Ribble Valley Borough Council
Council Officers, Church Walk
Clitheroe
BB7 2RA

Your ref 3/2011/1003
Our ref DC/12/323
Date 08-FEB-12

Location : land next to 14 Church Raikie Chipping Lancashire PR3 2QL
Proposal : Eight houses comprising six 3 bedroom five person houses for social rent and two 4 bedroom houses for private sale.

Scale: 1:500
Drawing No: 09-1441-P01

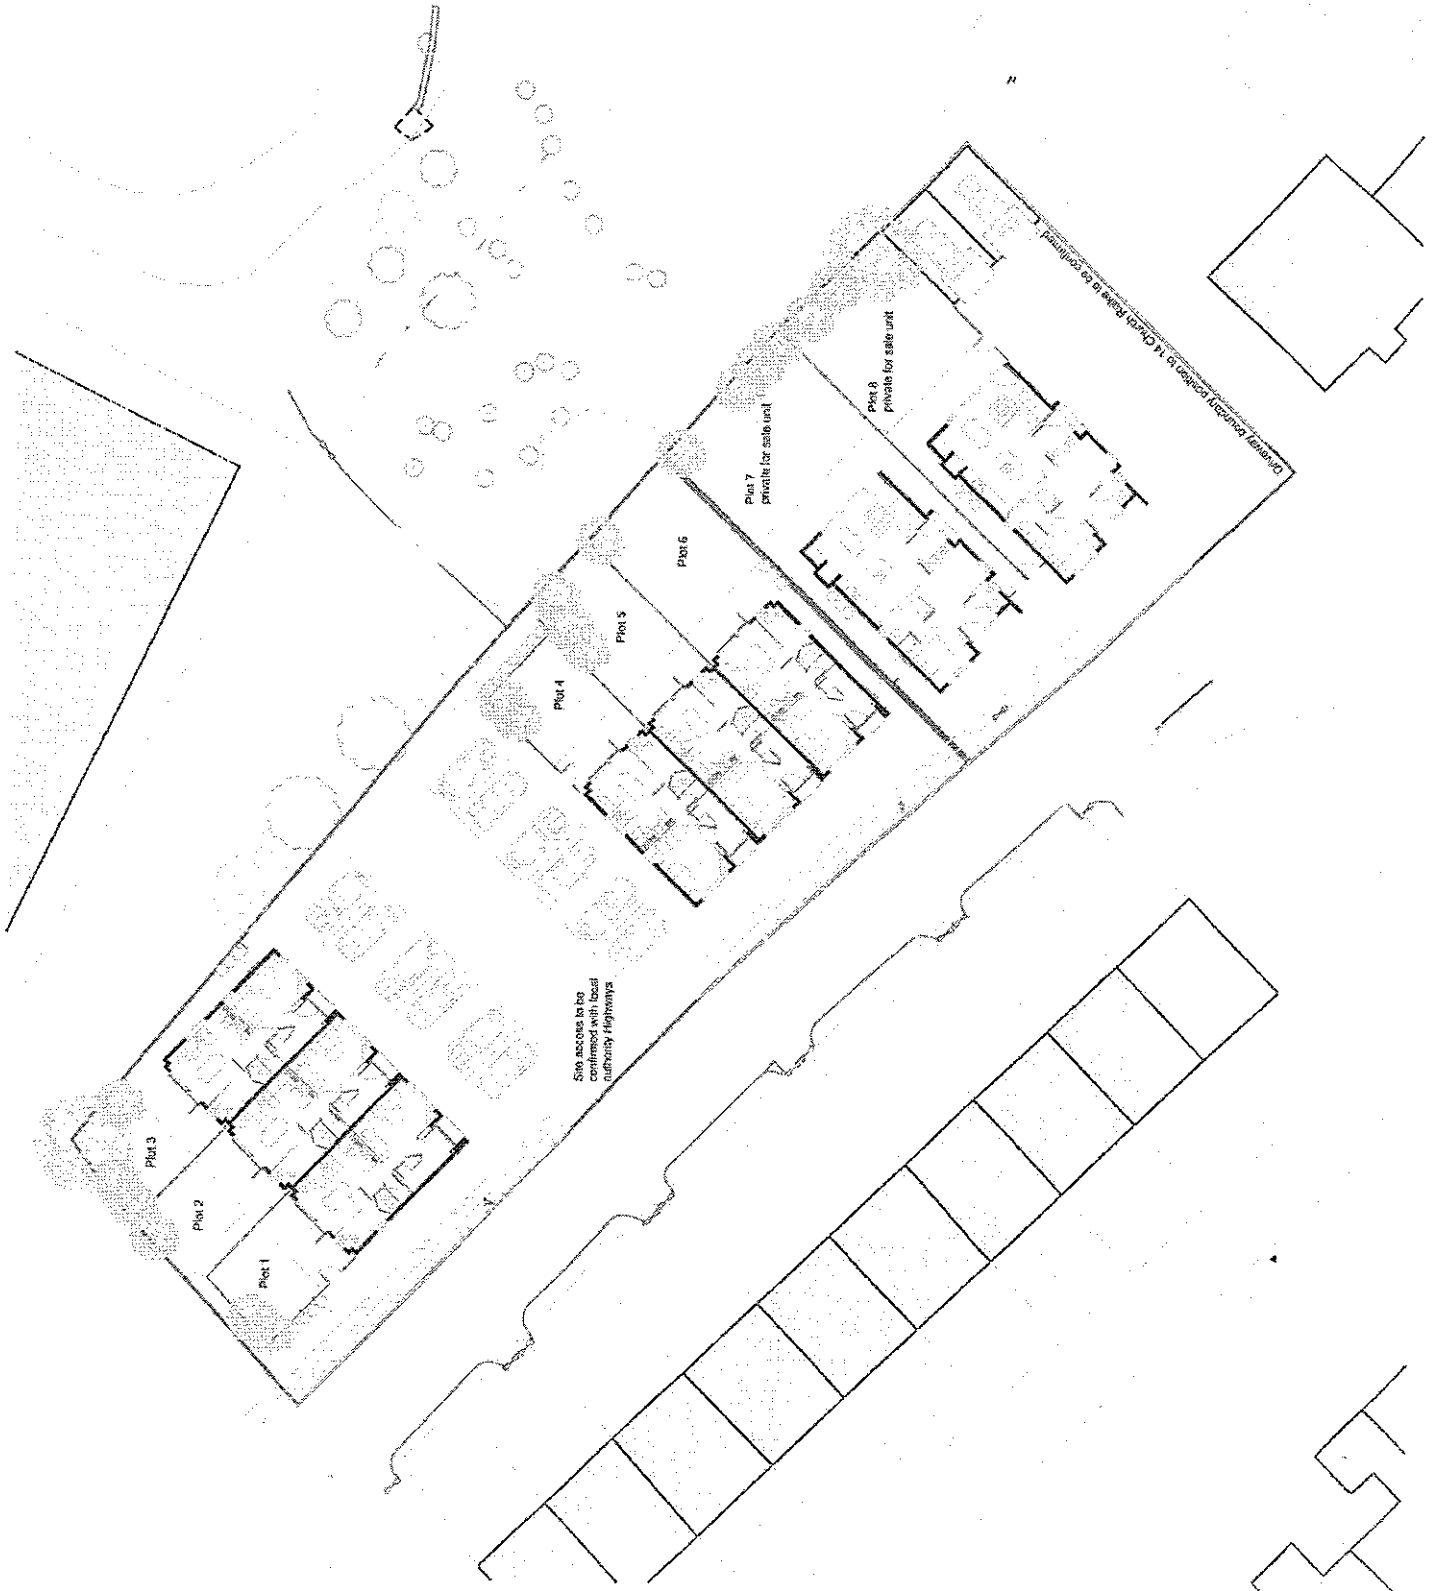
A large diameter raw water main crosses the site. As we need access for operating and maintaining it, we will not permit development in close proximity to the main. A modification of the site layout will be necessary. It is not possible to divert the main. United Utilities require an easement of 10m (5m either side of the centre line of the aqueduct).
